Your ref: SSD 30923027  
File no: MC-22-00001

**SSD 30923027 – Compass 2 Warehouse and Distribution Centre, Eastern Creek Drive, Eastern Creek.**

# **Blacktown Council's submission to SSD 30923027– Compass 2 Warehouse and Distribution Centre**

### CAR PARK DETAIL

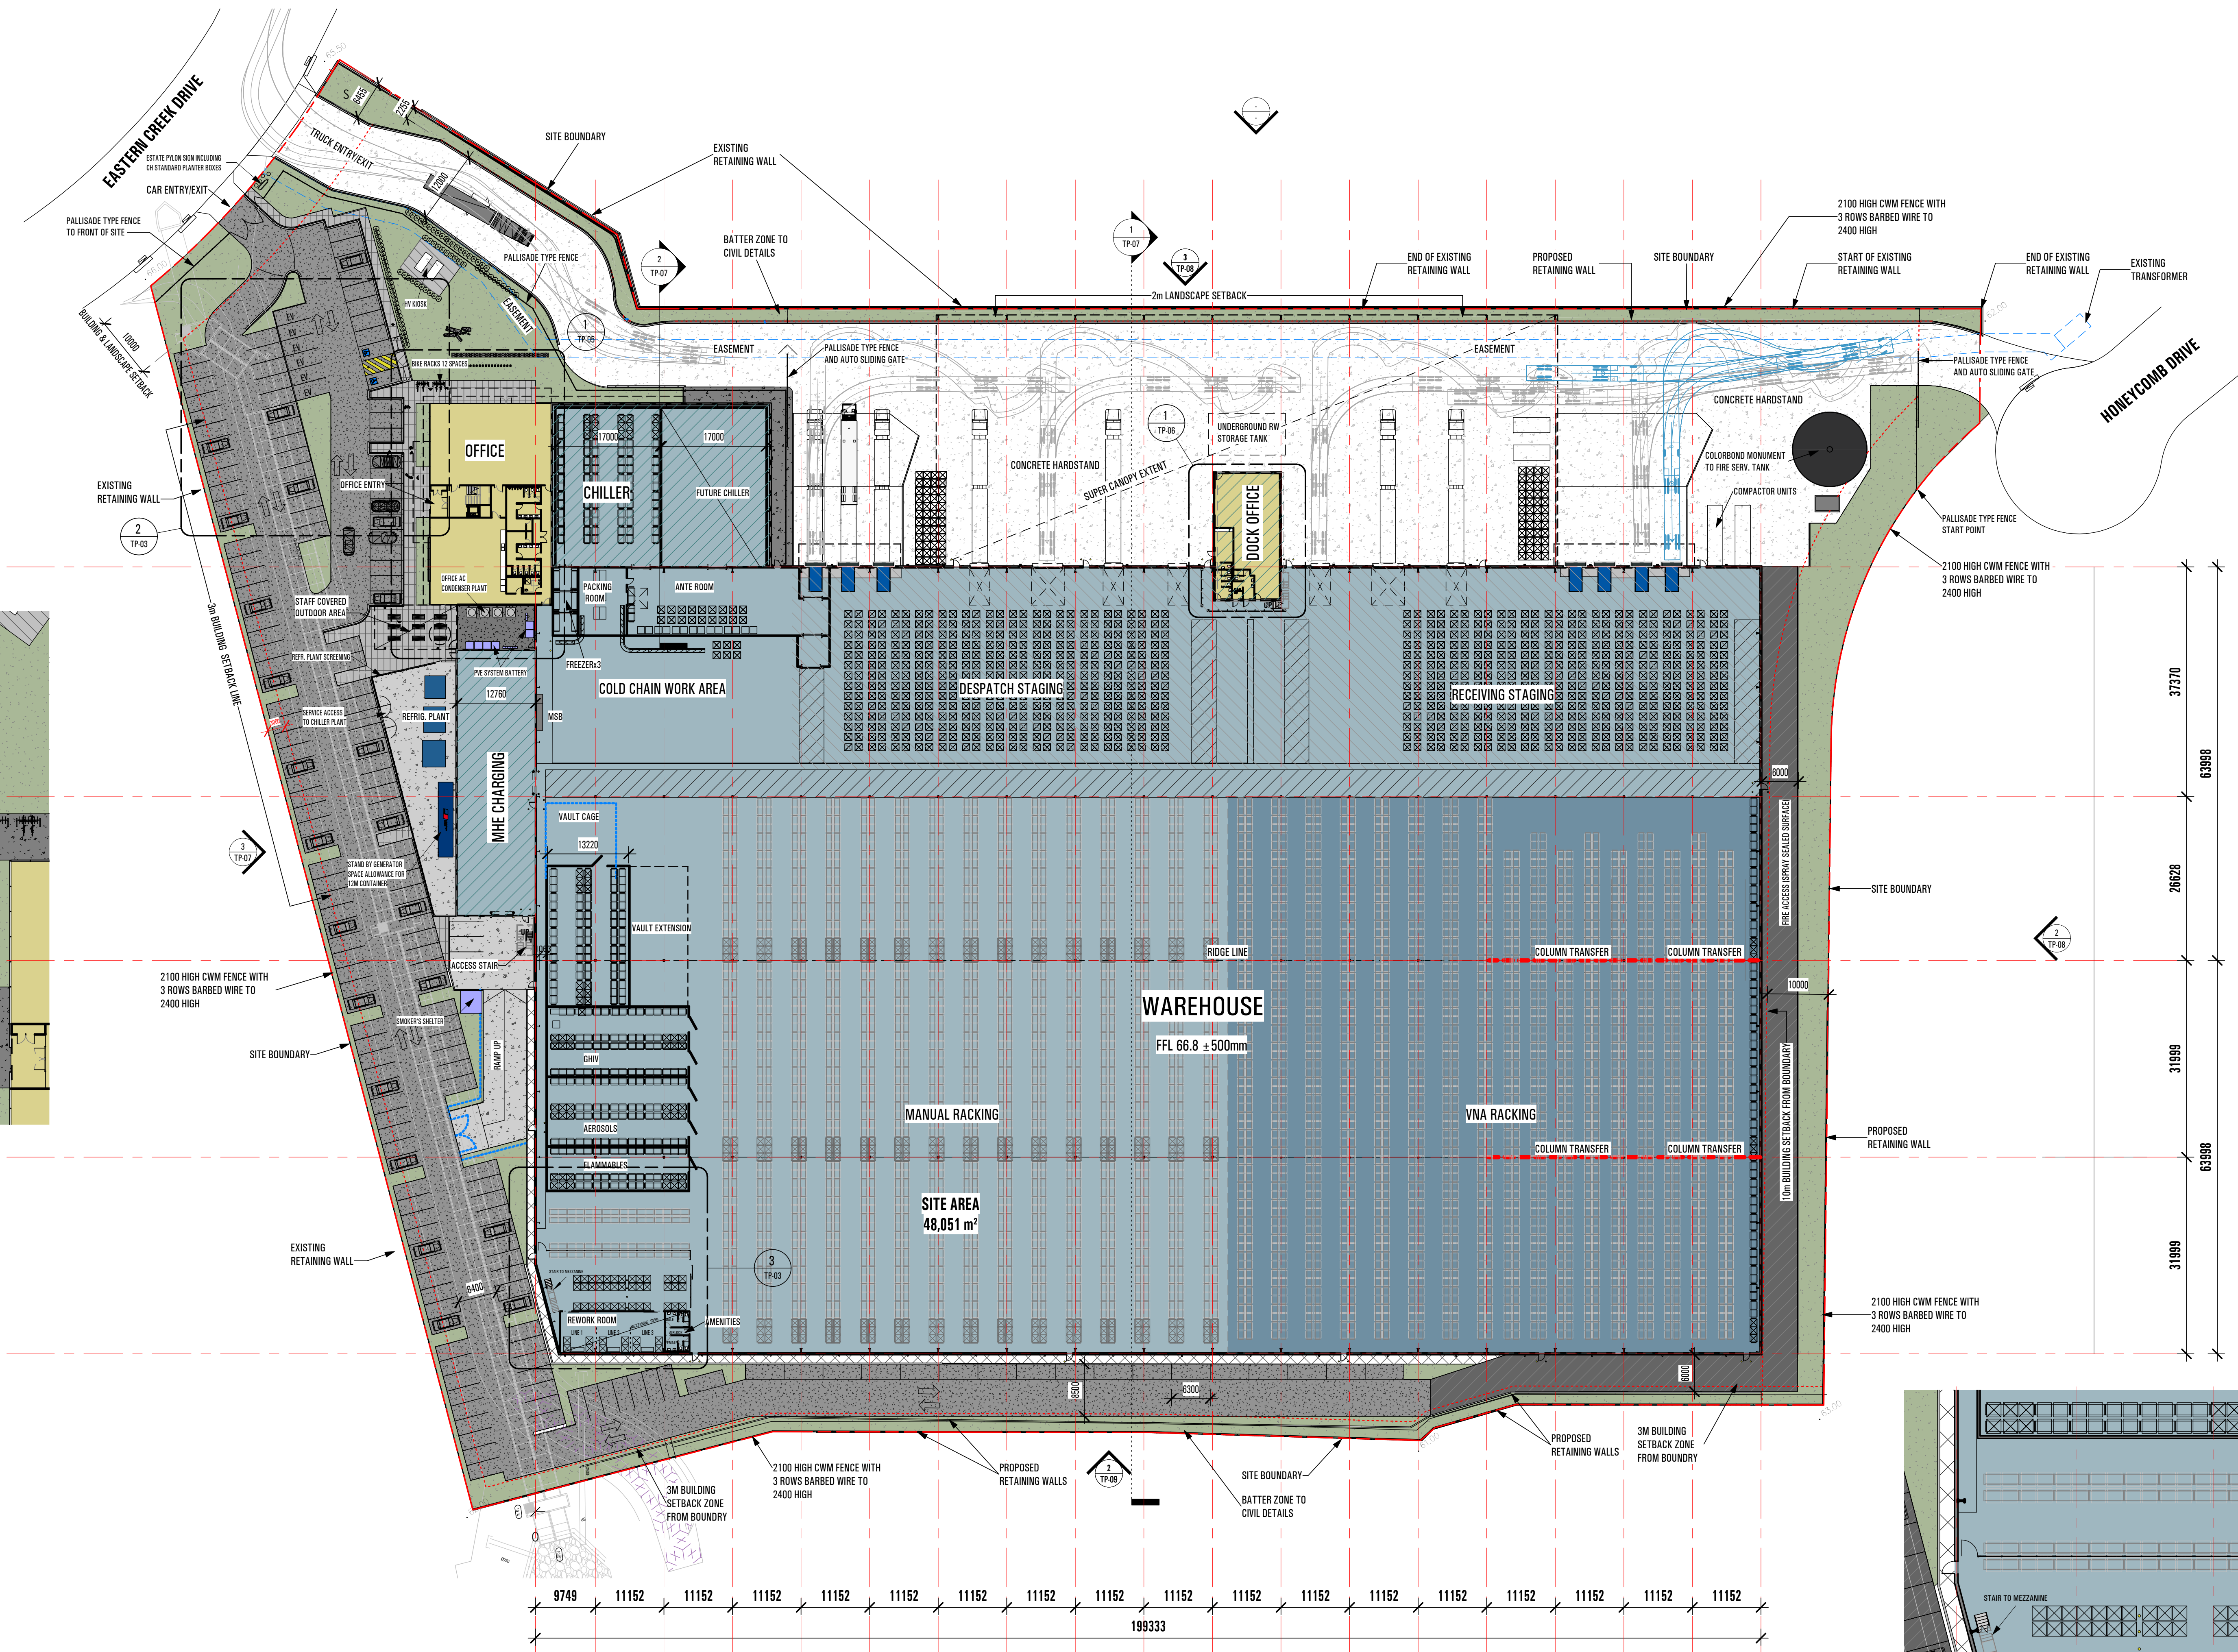
- f. The development is to provide parking in accordance with the requirements outlined within the Eastern Creek Precinct Plan Stage 3.
- g. In accordance with the Eastern Creek Precinct Plan Stage 3, a minimum of 2% of parking spaces are to be allocated as disabled parking. At present, there is a shortfall of 2 disabled parking spaces required for the development.

- h. The design of the car park and access must comply with AS2890.1, AS2890.6 and AS2890.2 as applicable.
- i. The loading dock area must comply with manoeuvring requirements of AS2890.2

SHEET NAME: SIGNAGE PLAN
JOB NO. 4387-21 **SCALE:** 1:750 **0011 SIZED SHEET**
Drawing No: TP-03.1 **ISSUE DATE:** 29/6/2022 **PROJECT AUTHOR**
REVISION: H **DRAWN BY:** FF

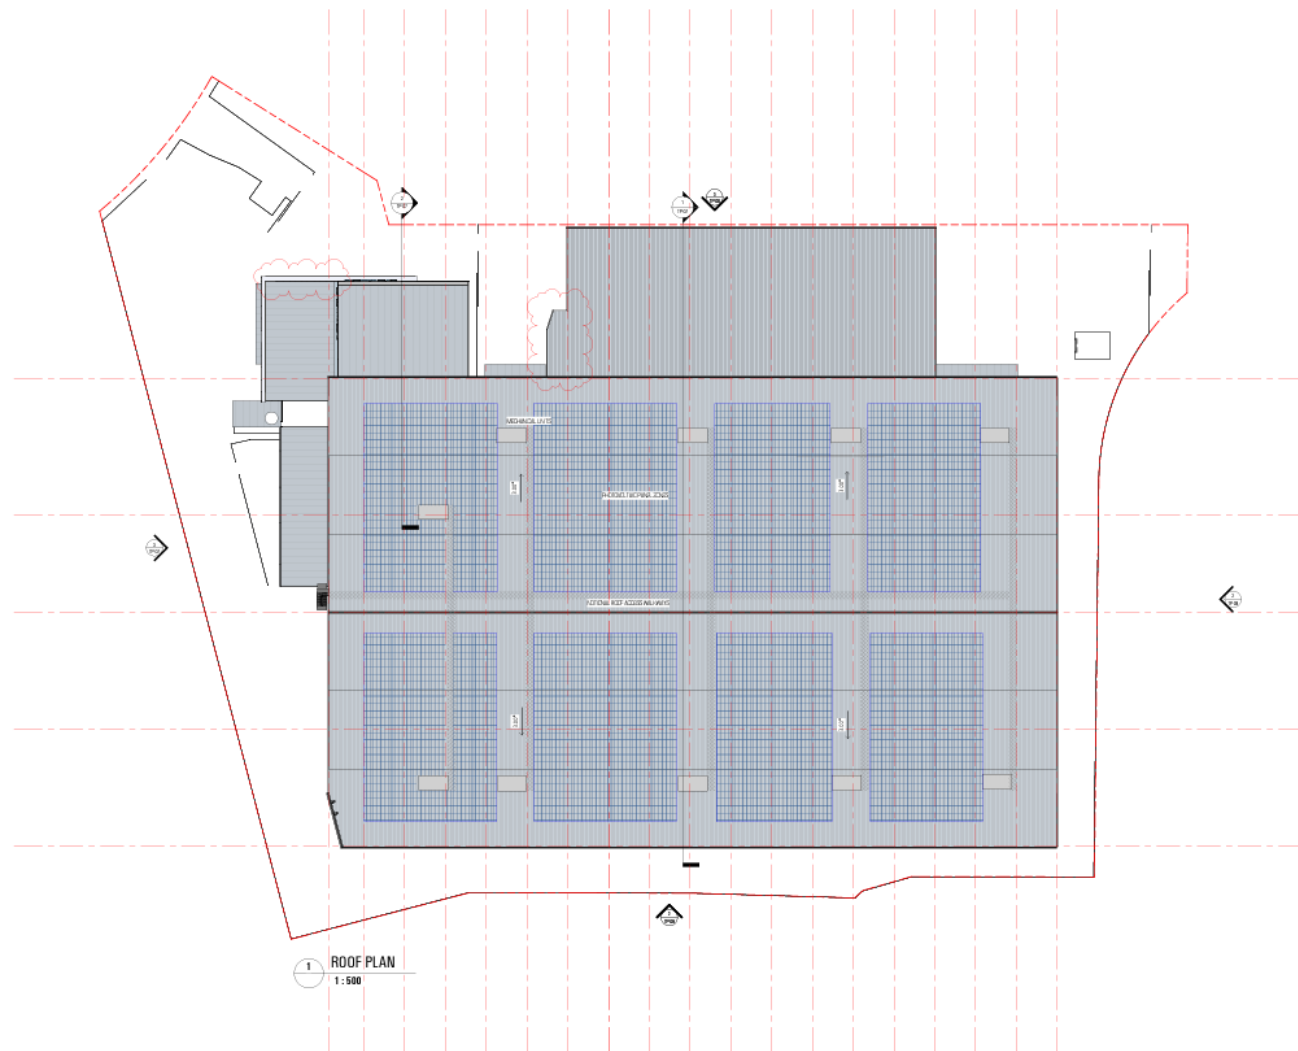
- l. Any signage proposed must be accompanied by an assessment against Schedule 5 of the Industry and Employment State Environmental Planning Policy 2022 and detailed on elevation plans.
- m. Clarification is required regarding the end user of the warehouse and distribution centre; the EIS refers to a single committed tenant however the signage plans indicate that there may be more than one tenant occupying the premises. The proponent is to ensure both tenancies can safely co-exist with one another and not cause any undue traffic, acoustic or pollution impacts on the surrounding locality.
